**Application Reference:** 2025/0935

**Site Address:** 27 Hunters Rise, Pogmoor, Barnsley, S75 2JX

**Introduction:** Proposed side two storey extension to dwelling.

plans as proposed

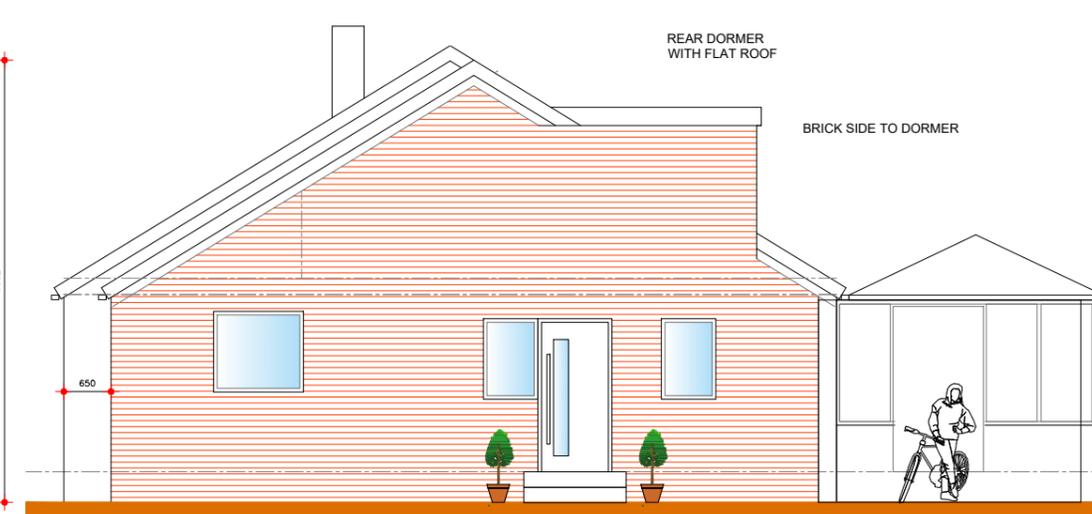
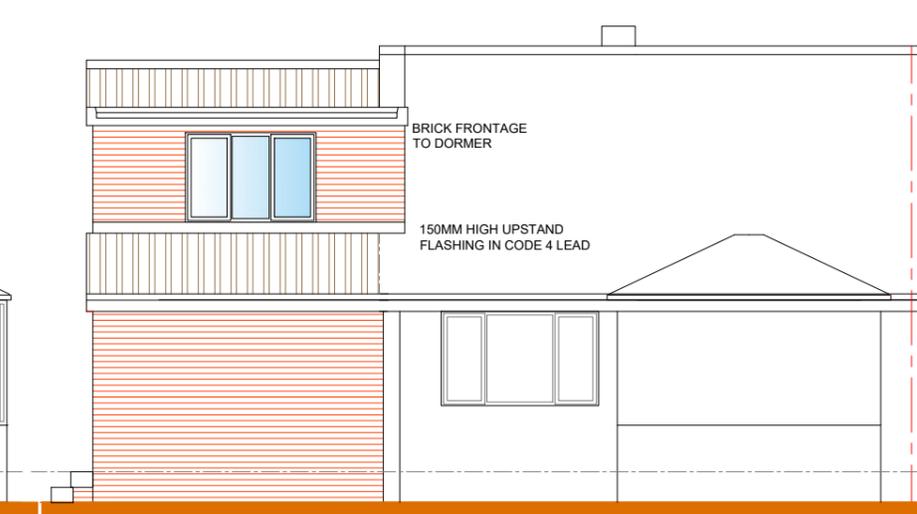
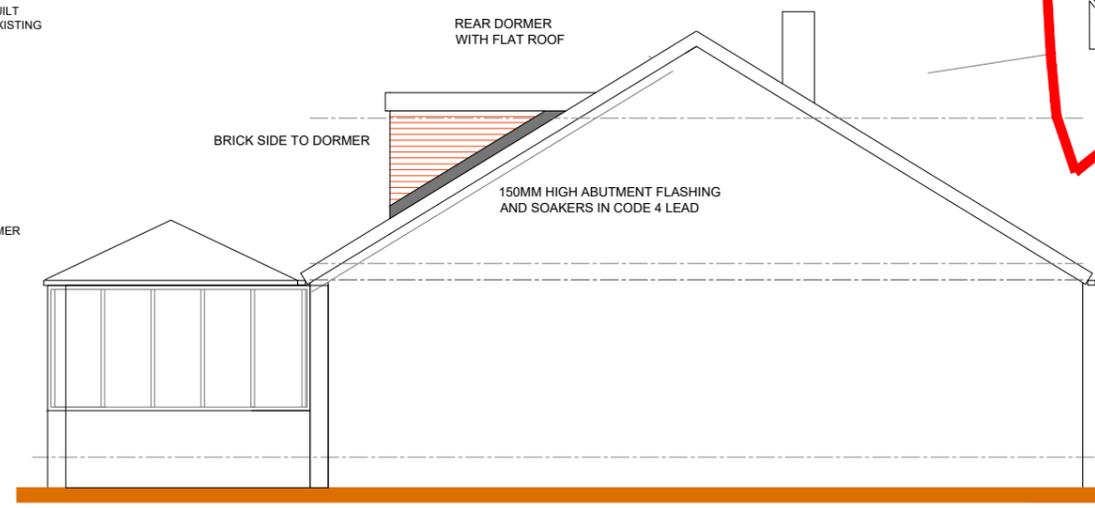
It has been necessary to make contact with the applicant regarding an amendment to provide glazing to the front elevation of the proposed extension in order to avoid a blank elevation within the street scene. Amendmenst were received on the 25<sup>th</sup> November 2025
